WEST SUSSEX COUNTY COUNCIL CONSULTATION

TO:	Chichester District Council FAO: Sascha Haigh
FROM:	WSCC - Highways Authority
DATE:	2 January 2024
LOCATION:	Harry's Fish And Chips, 105A Victoria Road, Chichester, PO19 7HZ
SUBJECT:	CC/23/02644/FUL Demolition of fish and chip shop and associated outbuildings and construction of 2 no. semi detached 2 bedroomed dwellings and one detached 2 bedroomed dwelling and associated private gardens and parking areas.
DATE OF SITE VISIT:	N/A
RECOMMENDATION:	Advice
S106 CONTRIBUTION TOTAL:	N/A

DETAILED PLAN

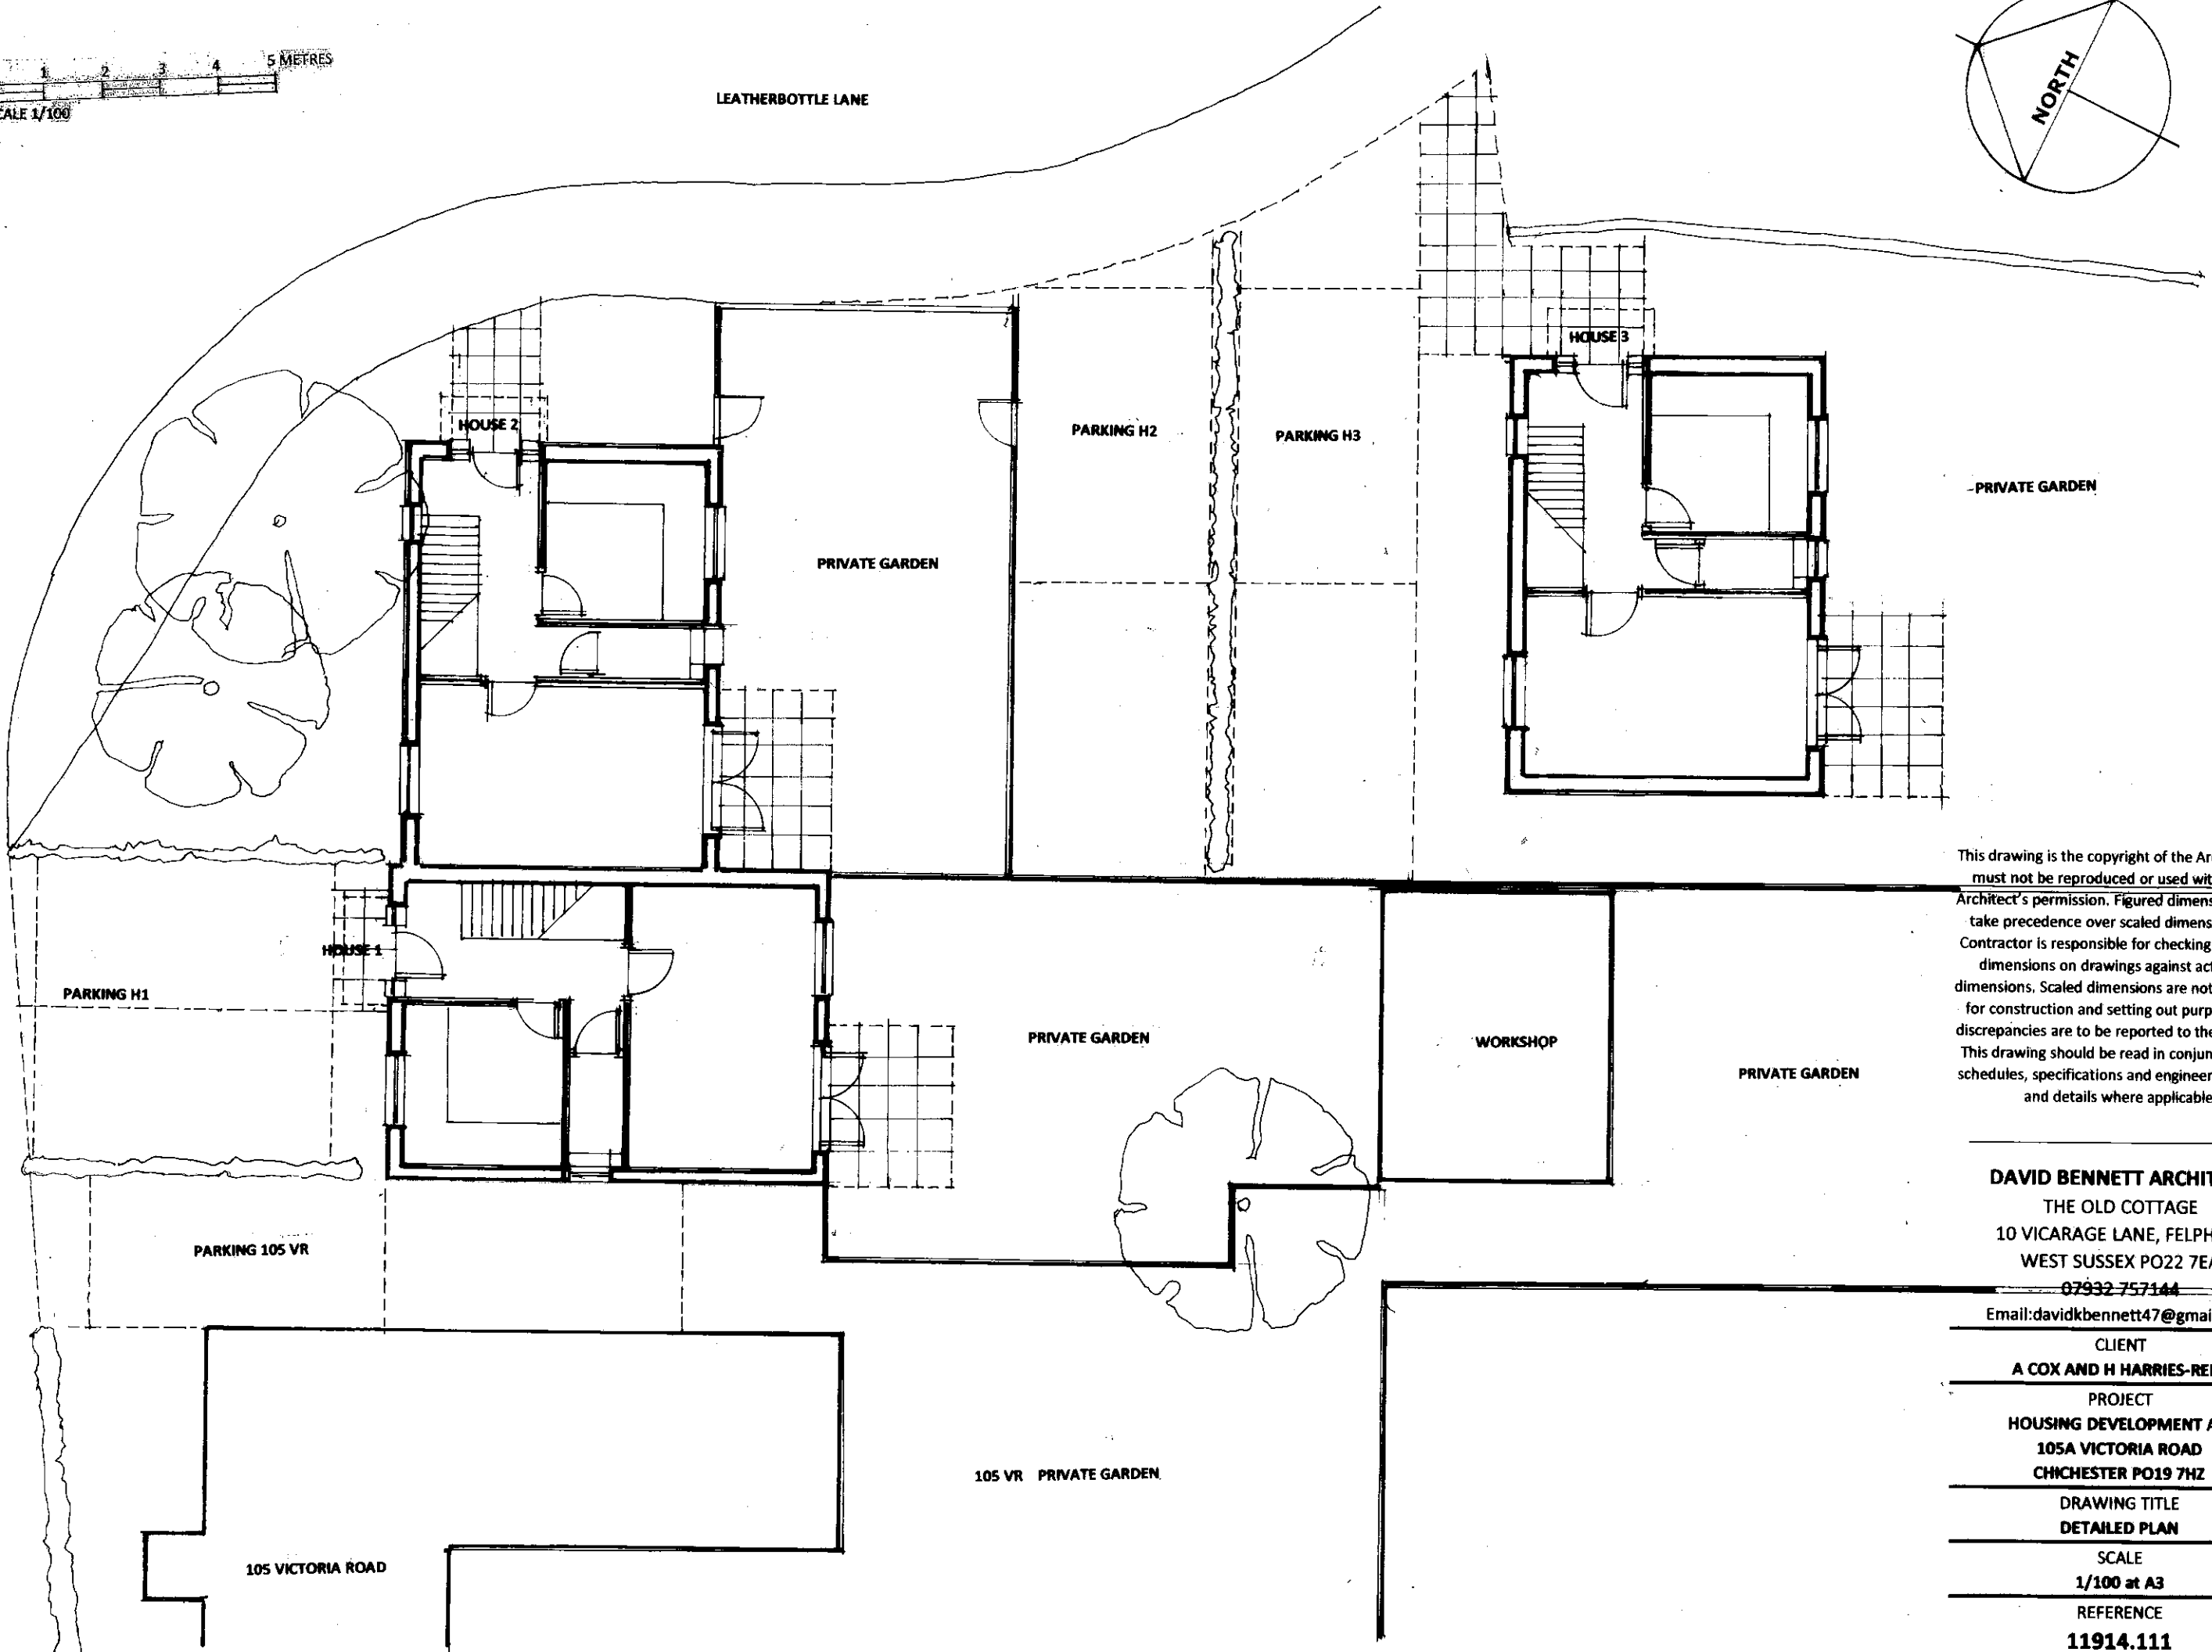
The proposals include two new vehicular access points from Victoria Road, to serve the existing dwelling and Plot 1, whilst the existing access from the privately maintained Leatherbottle Lane will be utilised to provide access to Plots 2 and 3.

For the proposed access from Victoria Road, a licence will need to be obtained through the local Highway Area Office to undertake the works, and the proposed access points will be constructed to a specification agreed with the local Highway Area Engineer. The existing access on Leatherbottle Lane may need to be widened to facilitate the proposed access points, and these will be subject to formal approval from the proprietor of the privately maintained road.

The WSCC Car Parking Demand Calculator indicates that the proposed residential development would require six car parking spaces. This has been demonstrated with each plot being provided with two parking spaces. An additional two parking spaces are also proposed for the existing dwelling.

From inspection of the plans, the proposed parking bays appear suitably sized. On-site turning does not appear achievable, so cars may have to exit the site in a reverse gear – however, this is not anticipated to give rise to an adverse highway safety impact in this location.

No details of cycle parking have been provided. Cycling is a viable option in the area and the LHA request secure and covered cycle parking provision for at least one bicycle per plot is provided in accordance with WSCC Parking Standards.

No part of the development shall be first occupied until the car parking has been constructed in accordance with the approved site plan. These spaces shall thereafter be retained at all times for their designated purpose.

No part of the development shall be first occupied until covered and secure cycle parking spaces have been provided in accordance with plans and details to be submitted to and approved by the Local Planning Authority.
